North Byron Parklands

Response to Submissions

MP09_0028 Modification 3 – Lodged May 2015

October 2015

Figure 2.2: Proposed noise limit zones and maximum measured  $L_{eq,oct(63Hz)}$ , SITG 2015 (dB)

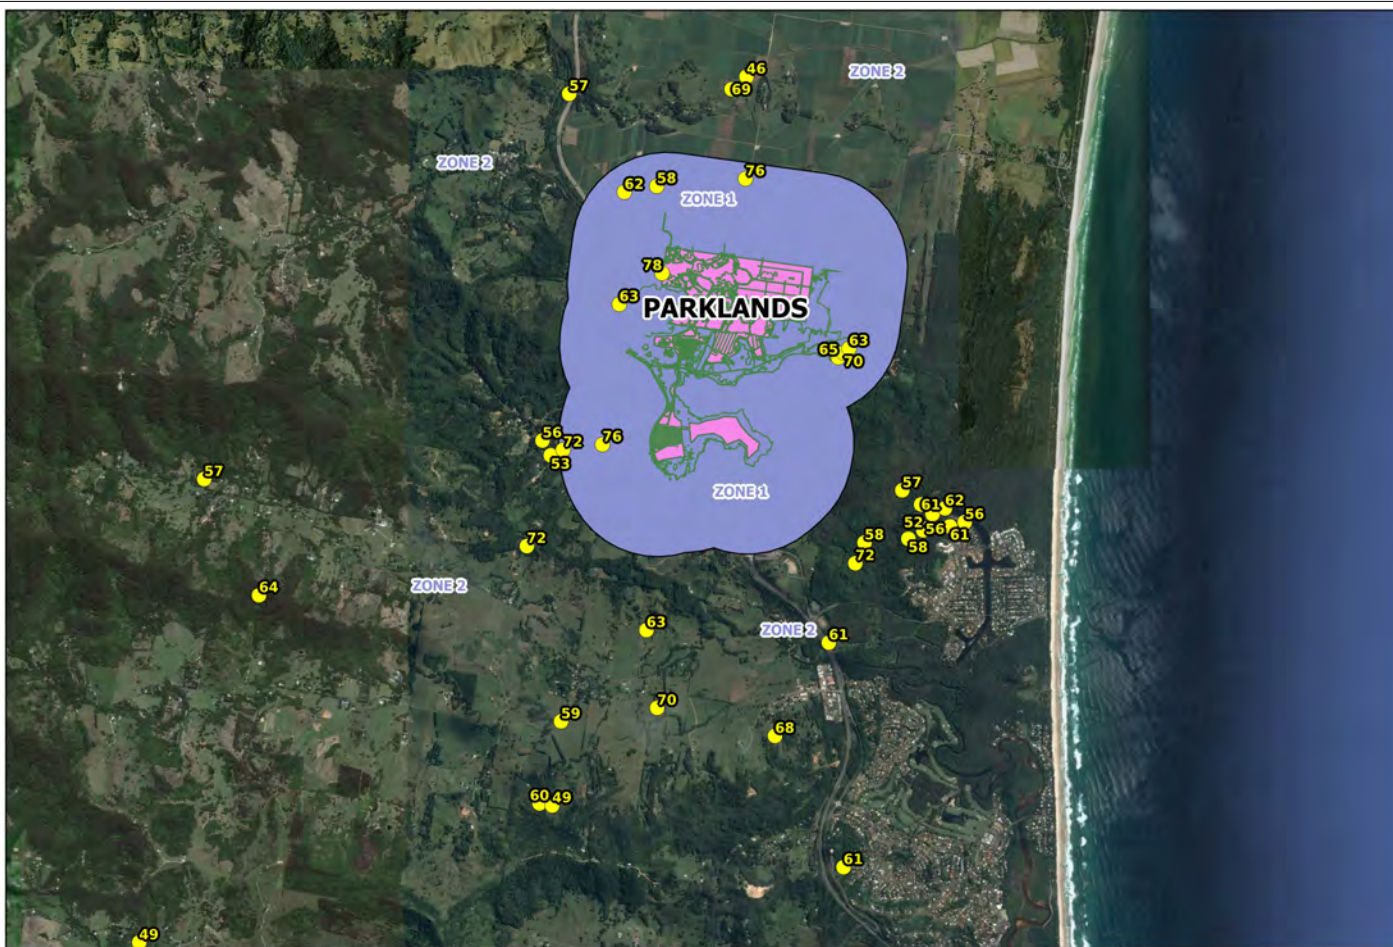
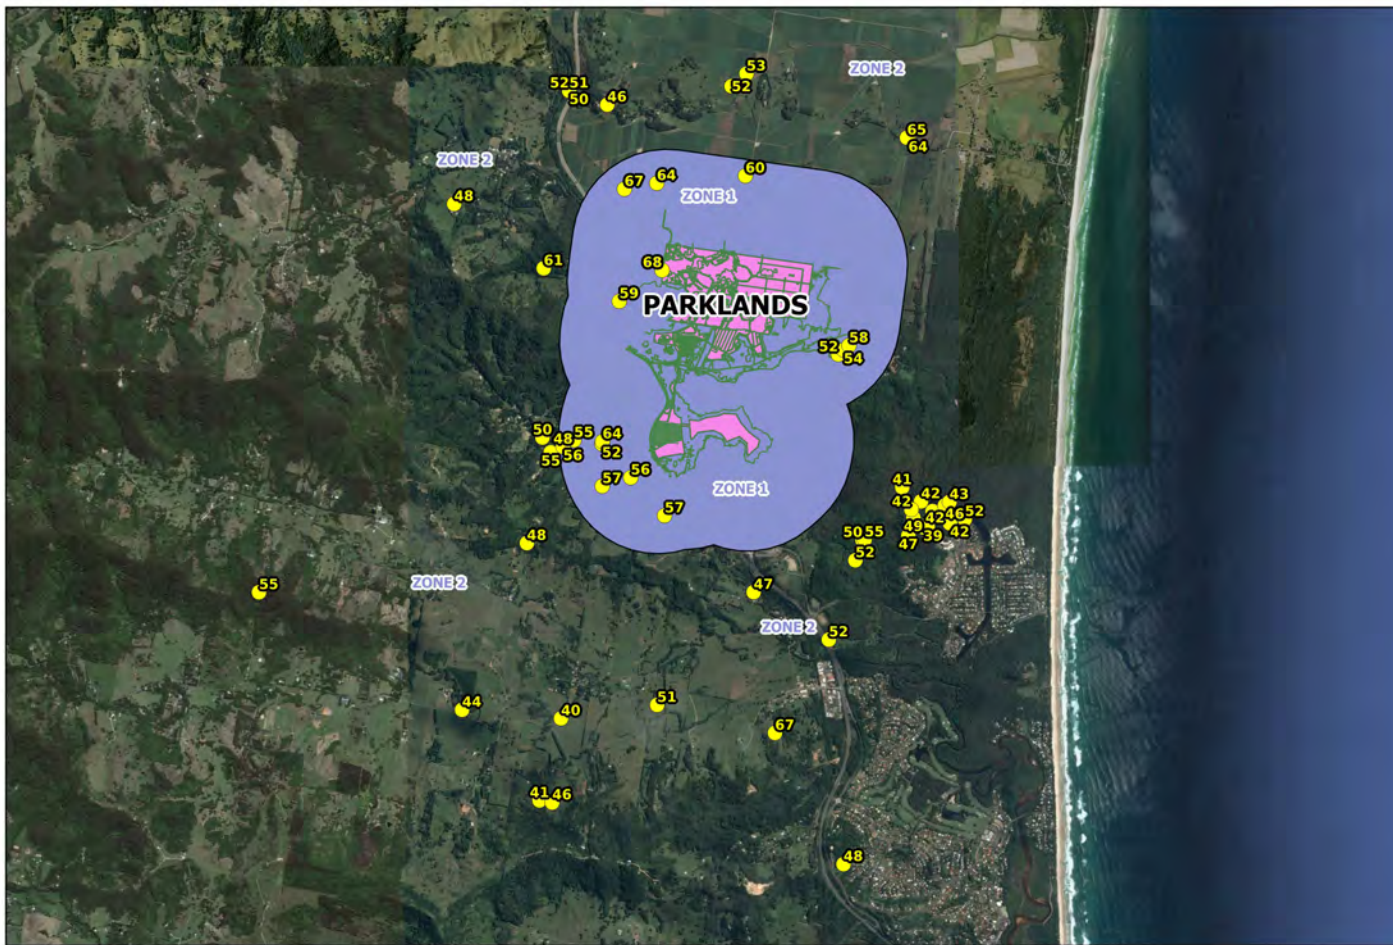
- Noise - The Department recommends reviewing the requested noise limits and providing 'zones' for varied noise levels i.e. those located in a zone where agreements are offered, and a zone for those outside this area. The data obtained from events held to date should be used to support the request showing how the levels can be met.

This data has shown that implementing a varied noise criteria based on two zones (an inner and outer zone arrangement) would mean that the noise criteria proposed for the outer zone could be

reduced from the blanket limits proposed in this modification. The data sets show that the inner zone could be based on a distance of one kilometre from the boundary of the venue property, while the outer zone would cover all areas surrounding the venue (including those with higher housing densities such as South Golden Beach, Fern Beach and North Ocean Shores). All receptors located in the inner zone have formal agreements in place with the venue (or receive tickets to the event) with respect to noise.

At a meeting with the DP&E Officers on 3rd of September 2015 revised noise criteria were proposed based on a zonal arrangement (see **Appendix D**) as follows:

Inner Zone

- Between 11am and midnight amplified entertainment noise from the event at sensitive receivers must not exceed 65dB(A) LAeq, 10-minutes or 75dB (lin) measured as Leq, 10-minutes in the 63 hertz 1/1 octave band; and
- Between midnight and 2am amplified entertainment noise from the event at sensitive receivers must not exceed 55dB(A) LAeq, 10-minutes or 70dB (lin) measured as Leq, 10-minutes in the 63 hertz 1/1 octave band.

Outer Zone

- Between 11am and midnight amplified entertainment noise from the event at sensitive receivers must not exceed 60dB(A) LAeq, 10-minutes or 70dB (lin) measured as Leq, 10-minutes in the 63 hertz 1/1 octave band; and
- Between midnight and 2am amplified entertainment noise from the event at sensitive receivers must not exceed 50dB(A) LAeq, 10-minutes or 65dB (lin) measured as Leq, 10-minutes in the 63 hertz 1/1 octave band.
